**Town & Country Planning Act 1990 (as amended)
Town & Country Planning (Development Management Procedure) (England) Order 2015**

Application for Planning Permission for Works or Extension to a Dwelling

Development: Change of use of some of our land from public amenity land to private garden, and erect new 1.8m wooden fence with concrete posts
Location: 3 Woodside Barnham PO22 0HZ

1:50 elevation plan

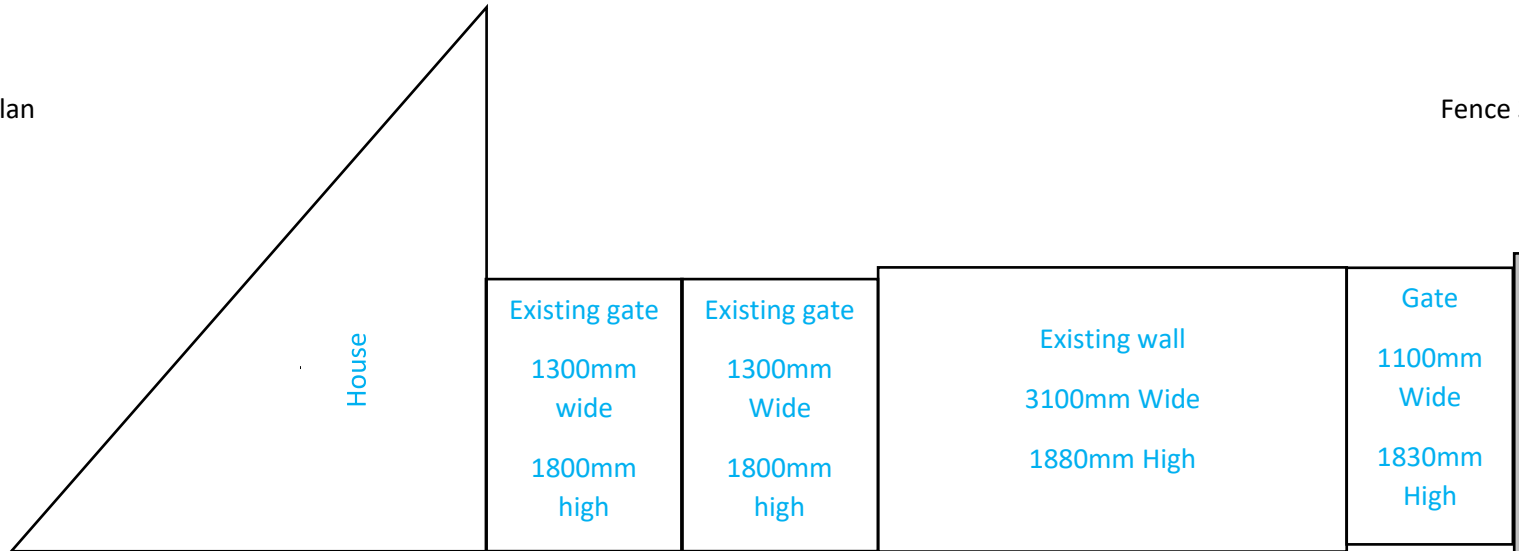
Elevations

Please submit a copy of clearly labelled existing and proposed elevations at a scale of 1:50 or 1:100. Further details can be found in the Validation Requirements List.

BLOCK PLAN

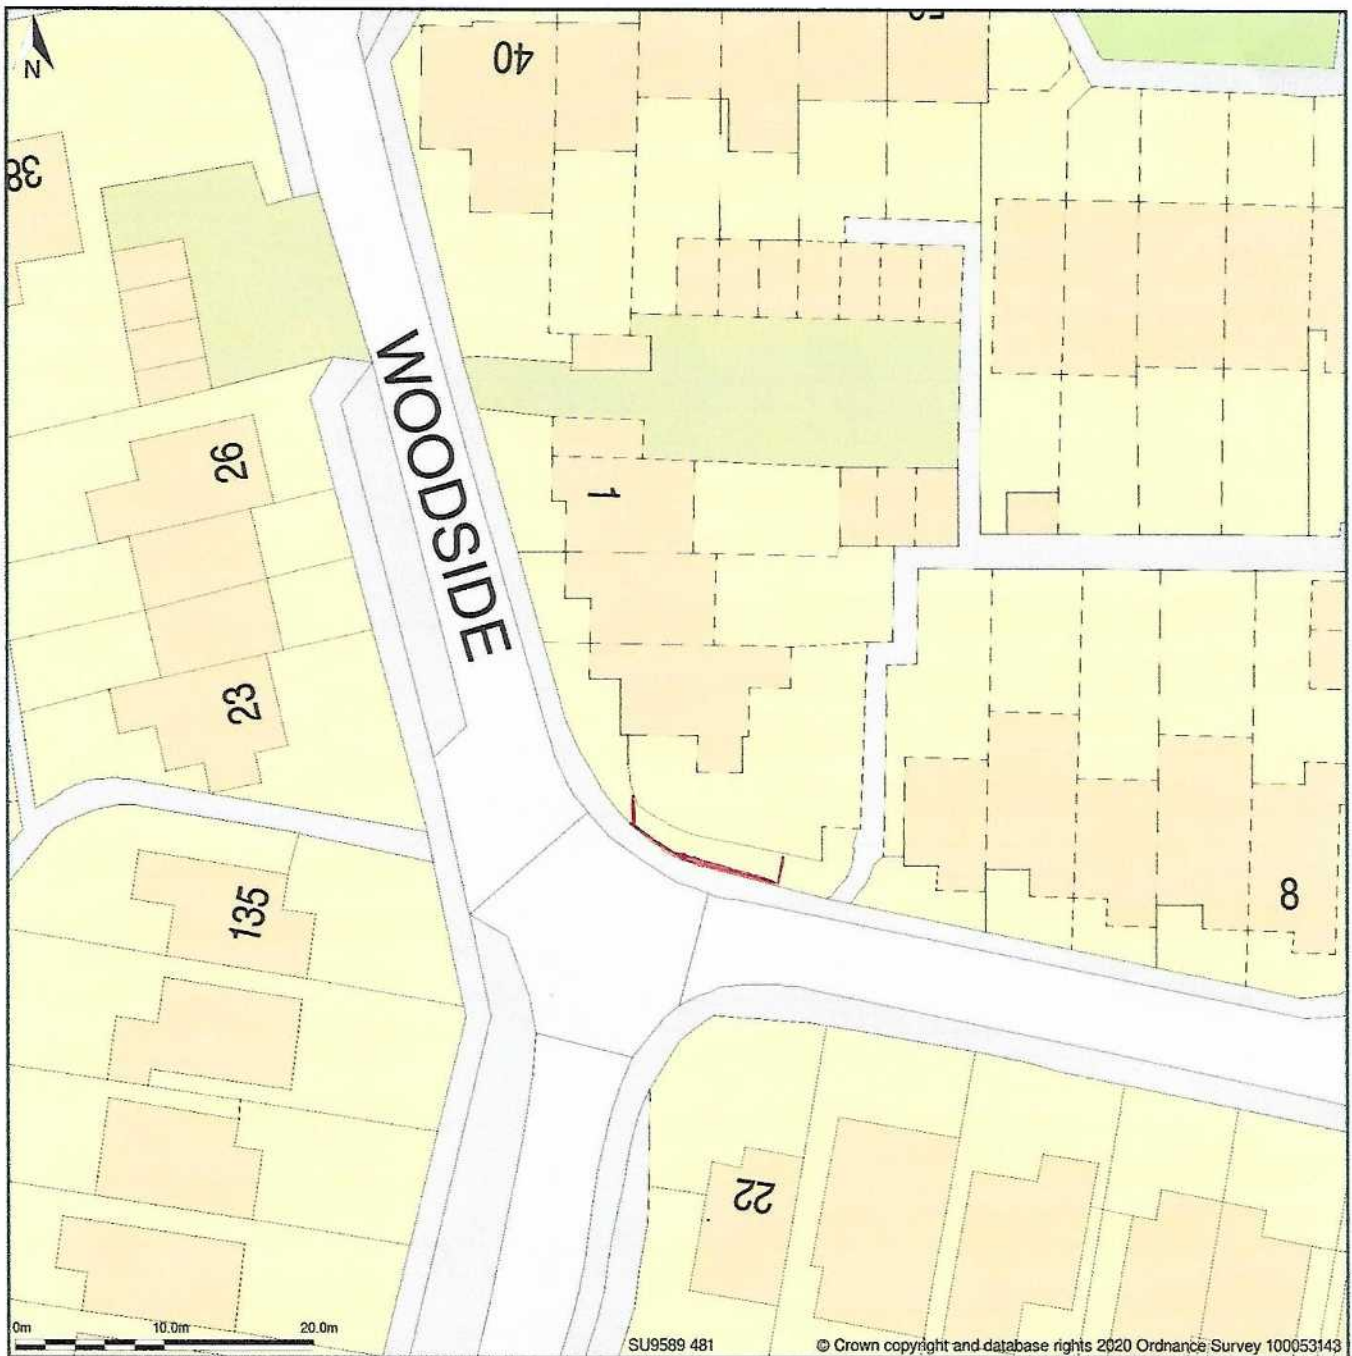
Block Plan

Please amend the scale bar on your Block Plan as this doesn't measure to scale. You are required to have dimensions from the proposed extension to all site boundaries. Please amend. Further details of what must be included on the plan can be found in the Validation Requirements List.
